KITTITAS COUNTY

MEMORANDUM

TO: All Staff
FROM: Public Works Plan Review Team
DATE: September 22, 2022
SUBJECT: BL-22-00021 Jones & Smith

PREPARED FOR MARK JONES A PORTION OF SECTION 1, TOWNSHIP 20 NORTH, RANGE 17 EAST, W.M. KITTITAS COUNTY WASHINGTON		
DWN BY GW/JR/DLP	DATE 8/2022	JOB NO. 21098
CHKD BY D.L.P.	SCALE 1" = 100'	SHEET 1 OF 2

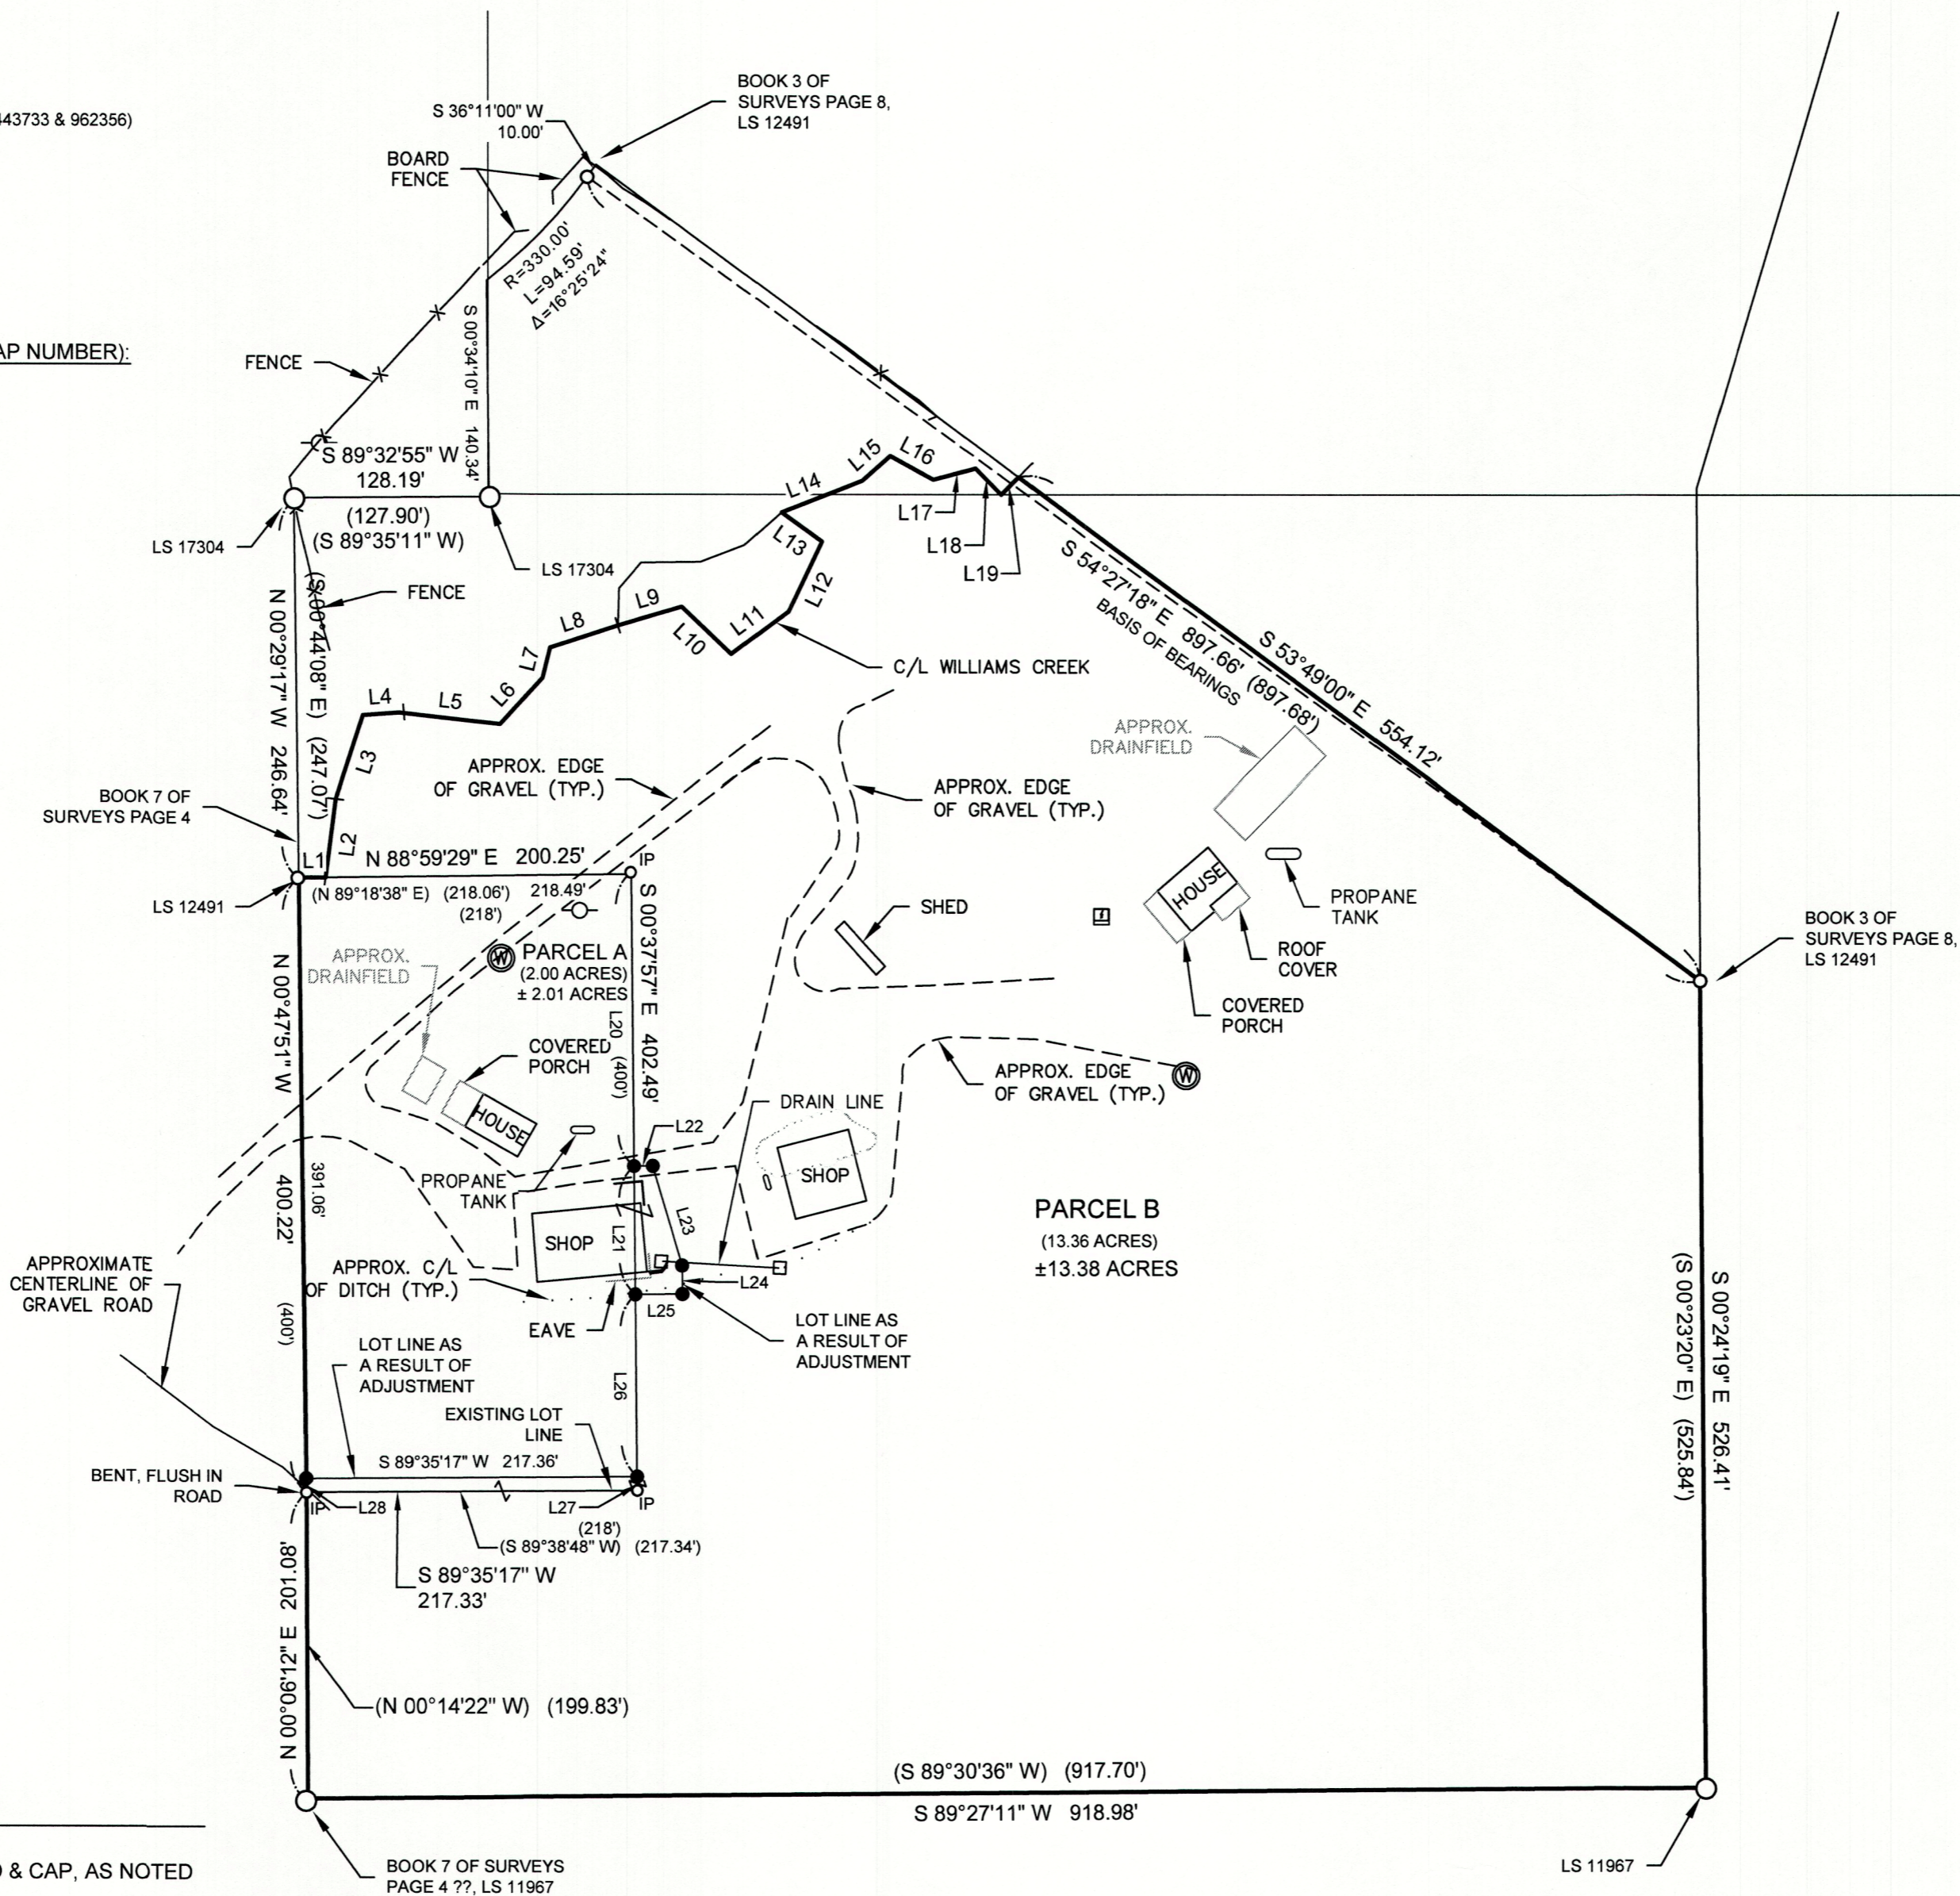
ACCESS	<ol style="list-style-type: none">1. An approved access permit shall be required from the Kittitas County Department of Public Works prior to creating any new driveway access or altering an existing access.2. Maintenance of driveway approaches shall be the responsibility of the owner whose property they serve. The County will not maintain accesses.3. Any further subdivision or lots to be served by proposed access may result in further access requirements. See Kittitas County Road Standards.4. In addition to the above-mentioned conditions, all applicable Kittitas County Road Standards apply to this proposal. Access is not guaranteed to any existing or created parcel on this application.
ENGINEERING	No Comments. (CC)
SURVEY	<p>As the provided map is seen as more of a site plan than a Survey map, the following comments are not intended to be comprehensive, and are rather just a few items that will need to be addressed as part of final review:</p> <ol style="list-style-type: none">1. Heading at the top of the page, including "Record of Survey" and Section, Township, and Range.2. Add the set corner symbol to the legend.3. The basis of bearing is confusing. The bearing, and the record distance shown does not match records, yet the bearing on the face of the map, that does not run between found corners (not on BOB line) appears to map record bearing. Further explanation may be required.
